LANDSCAPE PLAN

11745 OWL PLACE
LOT 4
EL PASO COUNTY, COLORADO

PCD File No. PPR2439

LANDSCAPE PLAN

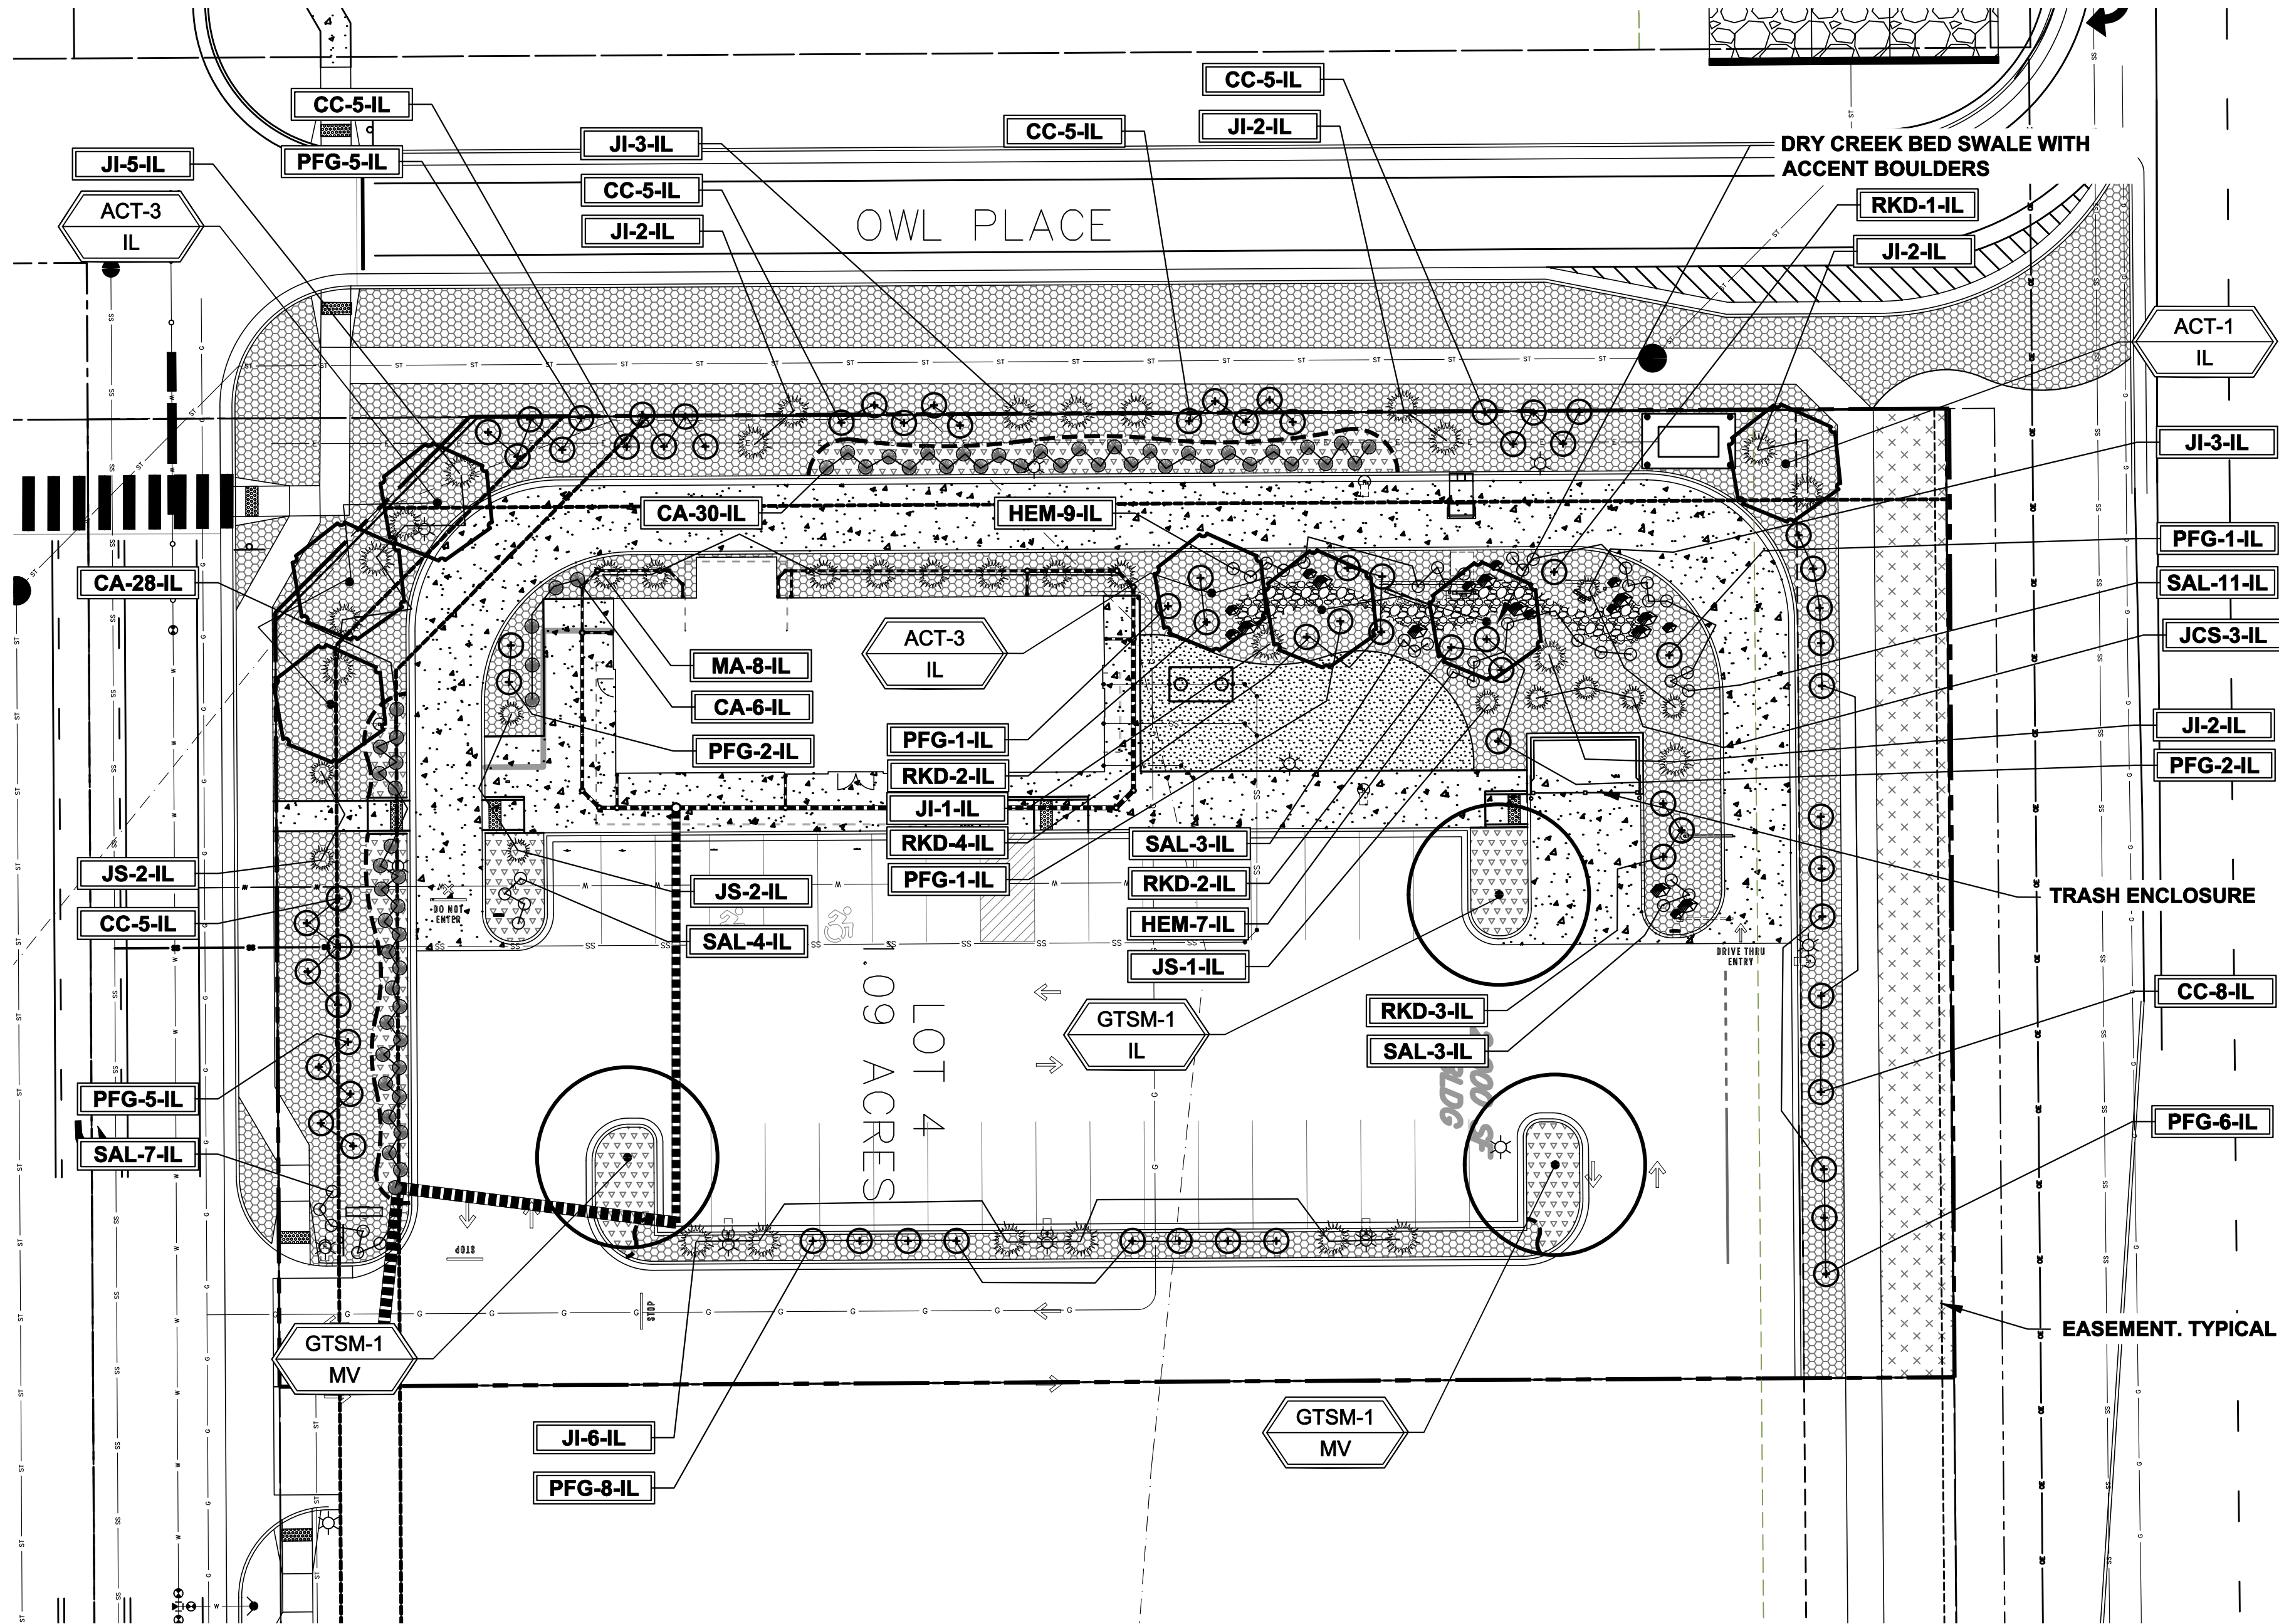
UNRESOLVED FROM REVIEW 1: Per Table 6-1 in the Land Development Code Owl Place and Meridian Park Drive are considered Non-Arterial roads and require 1 tree per 30 feet.

****NOTE:** If you are proposing to use shrubs in place of trees for this requirement, please discuss in the Letter of Intent as an Alternative Landscape Plan

UNRESOLVED FROM REVIEW 1: Because this stretch of parking exceeds 15 spots, you will need to include 1 parking lot island as per Section 6.2.2.C. in the Land Development Code, which states that 1 parking lot island shall be provided every 15 spaces to break up expanses of long rows of parking.

****NOTE:** If you cannot meet this standard, you can alternatively increase the landscaping on the corner islands and discuss in your Letter of Intent with your Alternative Landscape Plan
